Subject: App 2021/92009 Union Mills, Tanyard Road, Milnsbridge, HD3 4NB
Date: 28 June 2021 14:07:54

Having read the submitted information for this application. I am very happy with all but 1 of the points in answer to my comments dated 19th May 2021, that being the car park site lighting.

Richard Thornton
West Yorkshire Police
Designing Out Crime Officer
Kirklees District Planning Department
Civic Centre 1,
High Street,
Huddersfield
HD1 2NF

Proposed Site Plan 1:500@A4

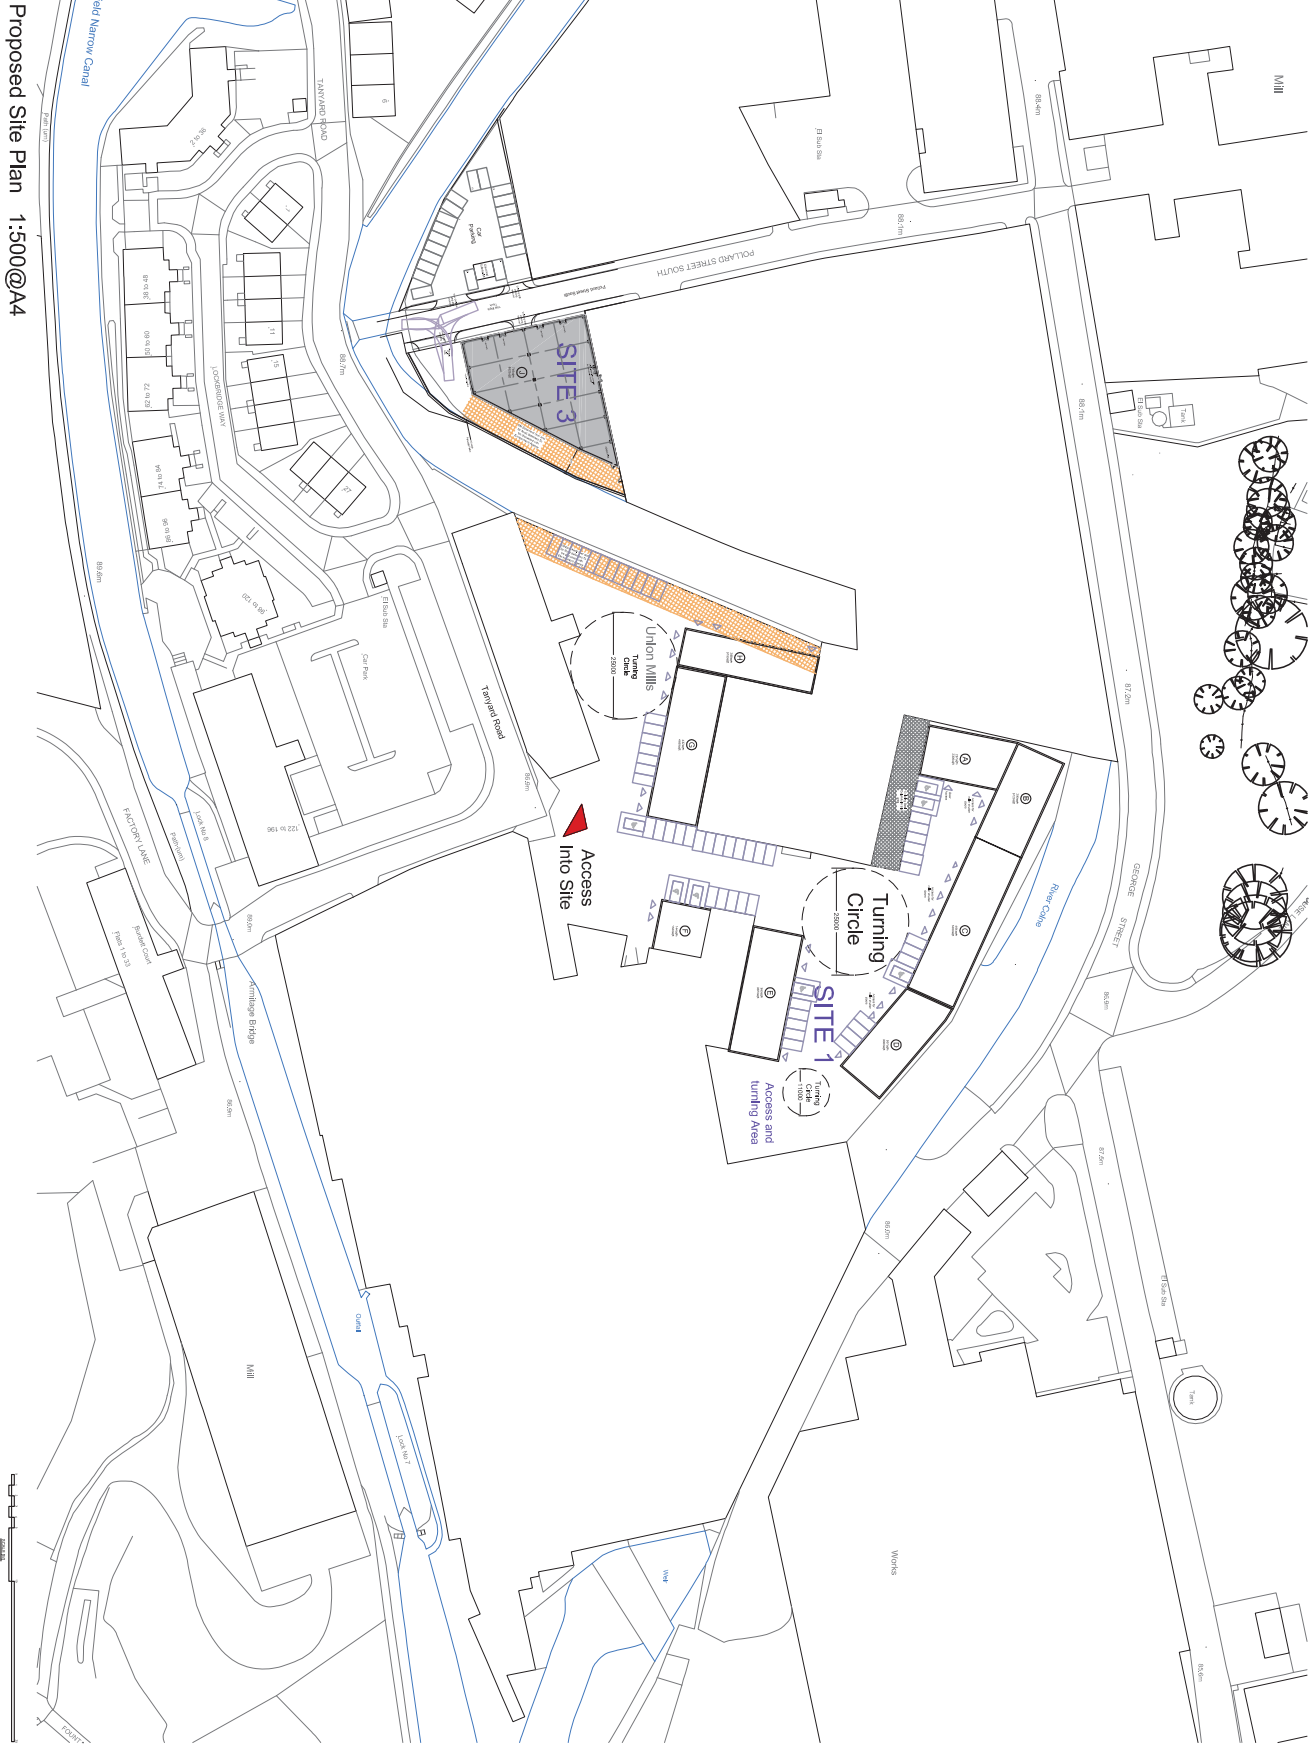
I would like to encourage the applicants to change the submitted lighting bollards to a lighting scheme that will incorporate the above advice and standards, thus maintaining the requirement for the ecology and site security.

If you have any questions, please come back to me so we can discuss them. At present I am still reluctant to discharge Condition 21 (Crime Prevention) until we have an agreement on the site lighting.
